The Member Secretary,  
Chennai Metropolitan  
Development Authority,  
No.1, Gandhi Irwin Road,  
CHENNAI -600 008.

Letter No. **BC1/7610/2003**

Dated: **04-09-2003**

Sub: **CMDA - Area Plans Unit - Planning Permission - Proposed construction of GF+2F Residential Building with 4 dwelling units at New Plot No.9, SBI Officers Colony, T.S.No.5/6, Block No.15, R.S.No.167pt of Arumbakkam, Chennai - Remittance of Development charge and other charges - Reg.**

SITE/GROUND FLOOR PLAN

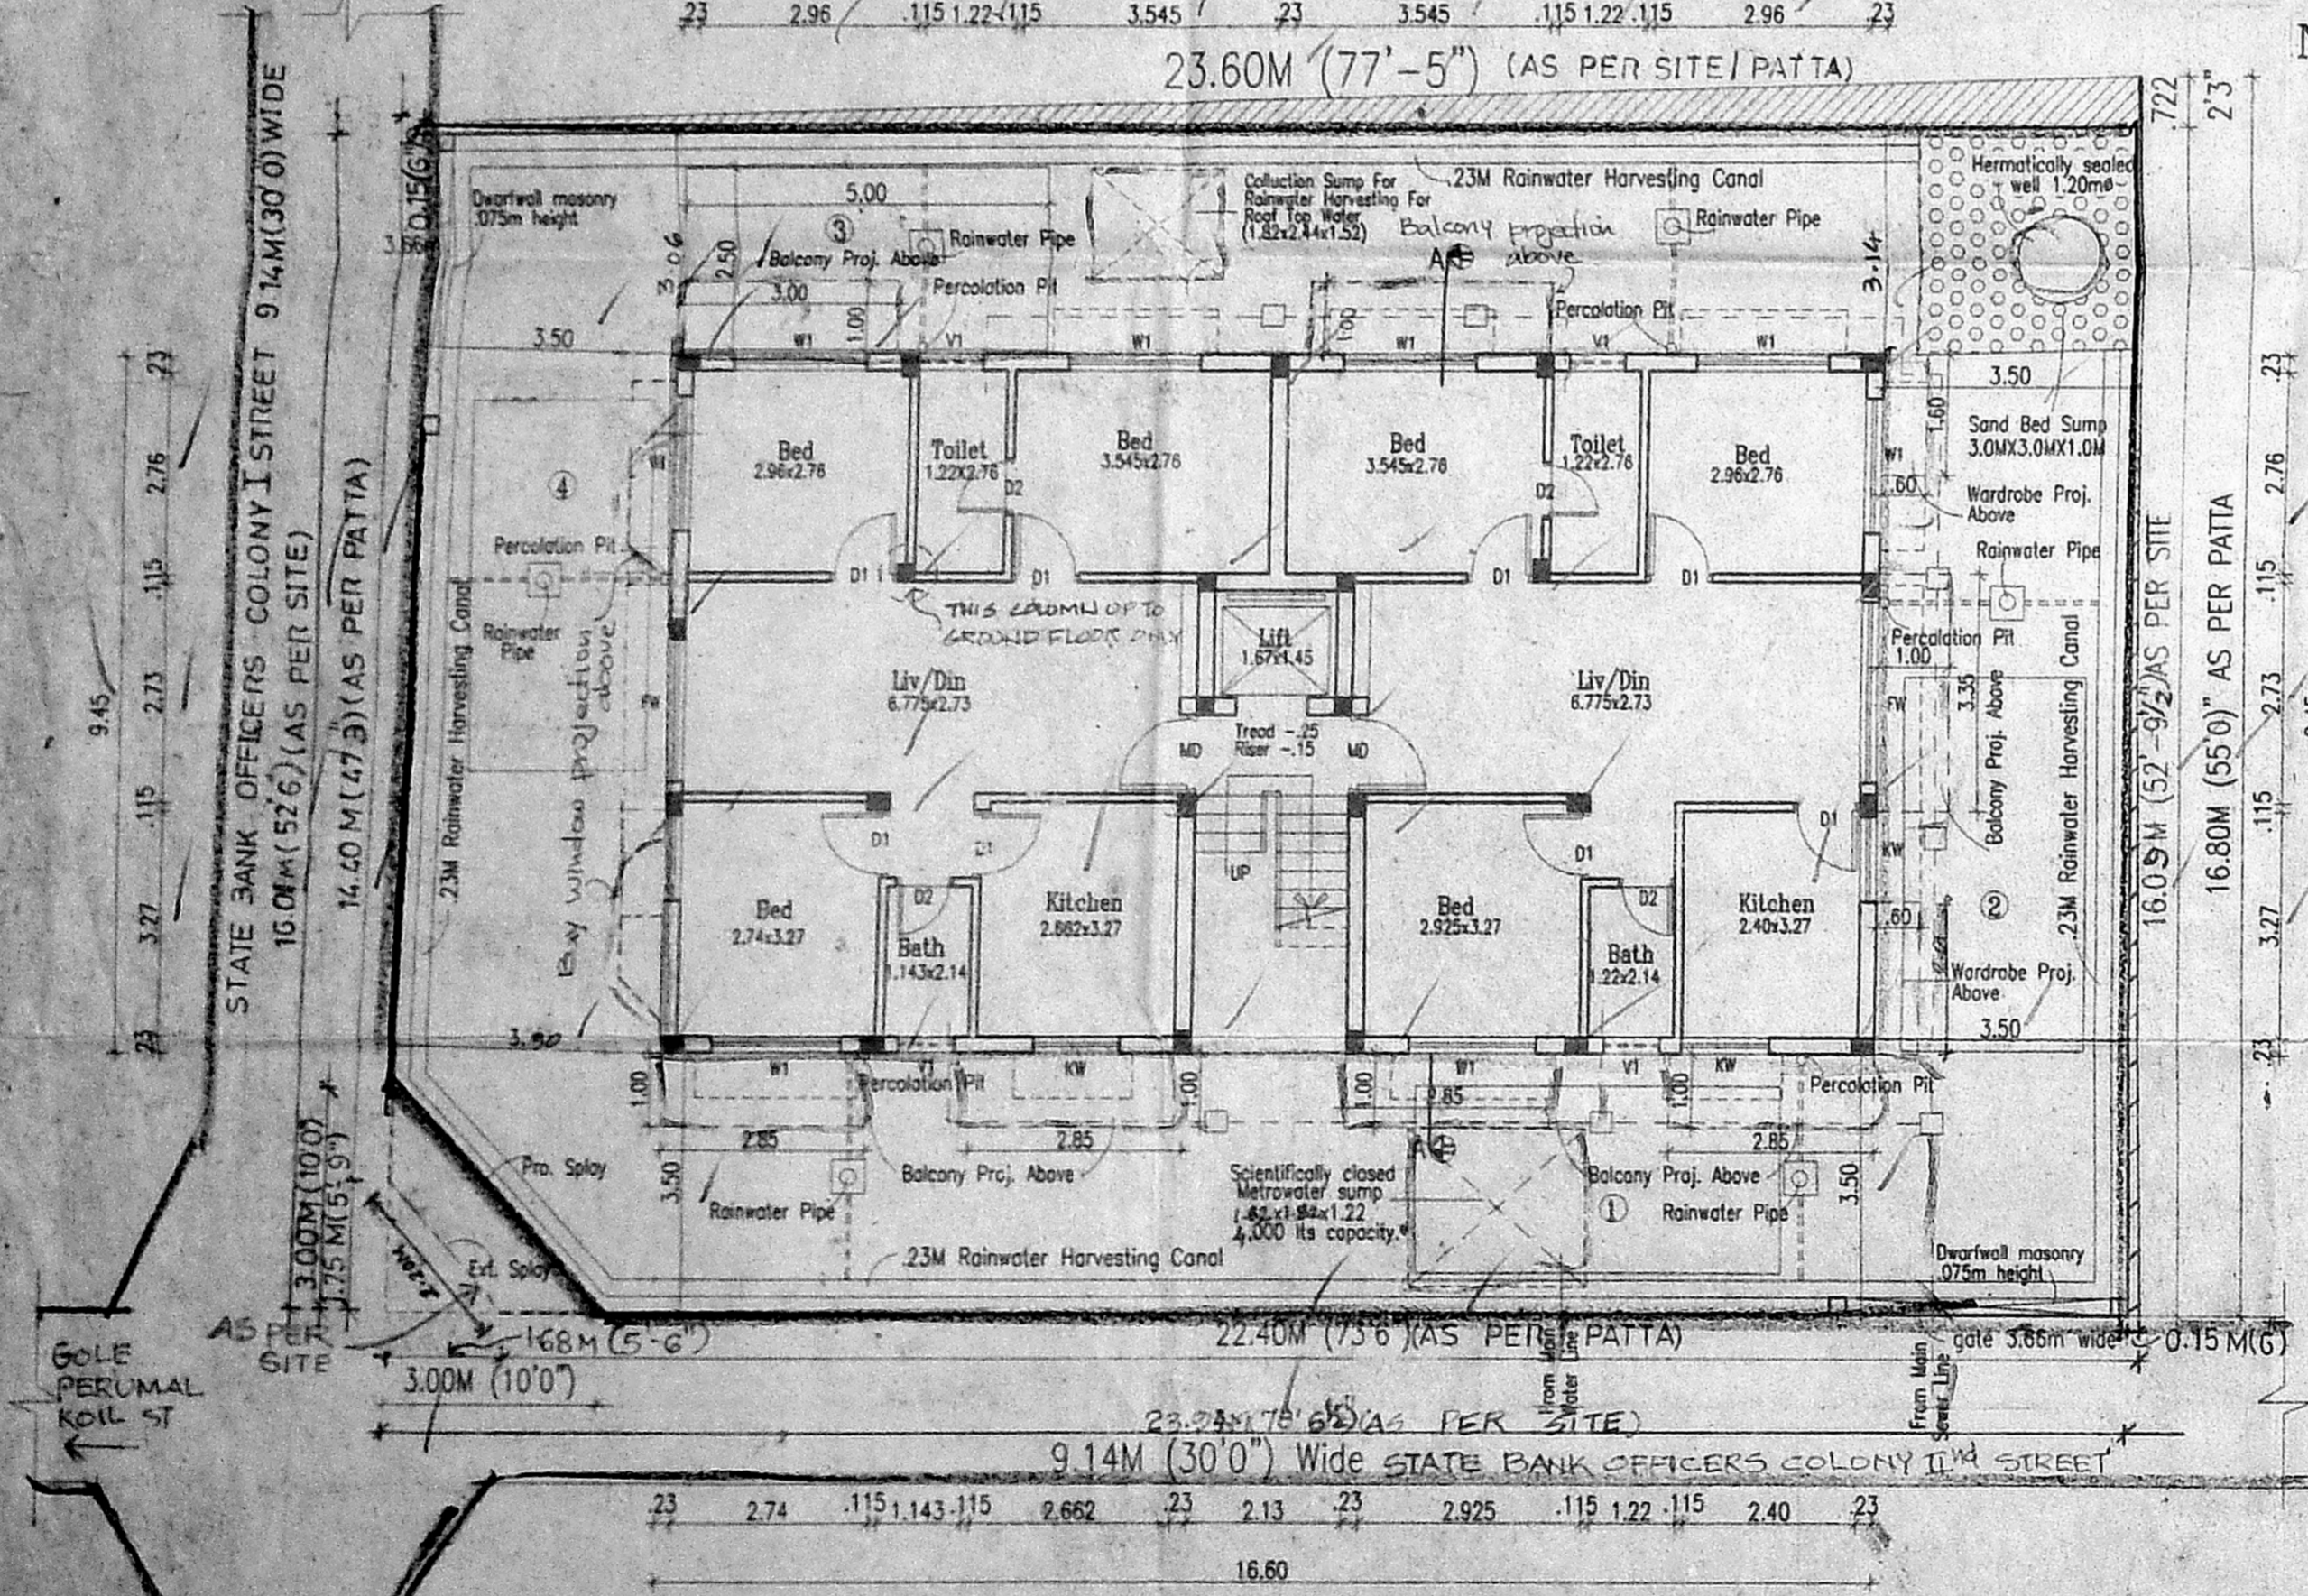
- i) Site dimension as on site do not tally with the TSLR dimensions therefore site plan is to be drawn showing both the dimensions as on site and as per TSLR distinguishing the difference by hatched indications and indicating the set back dimensions from the least dimension line and perpendicular to the site boundary.
- ii) Building plus set back dimensions do not tally with the least plot dimensions on both sides.
- iii) Metro Water sump capacity shall be restricted to 1000 litres per dwelling unit.
- iv) The word "self" to be deleted and the word "ward robe" to be inserted near staircase in 1st floor and 2nd floor plan.
- v) Revised plan showing the position of columns in Ground, First and 2nd Floor tallying with each other.
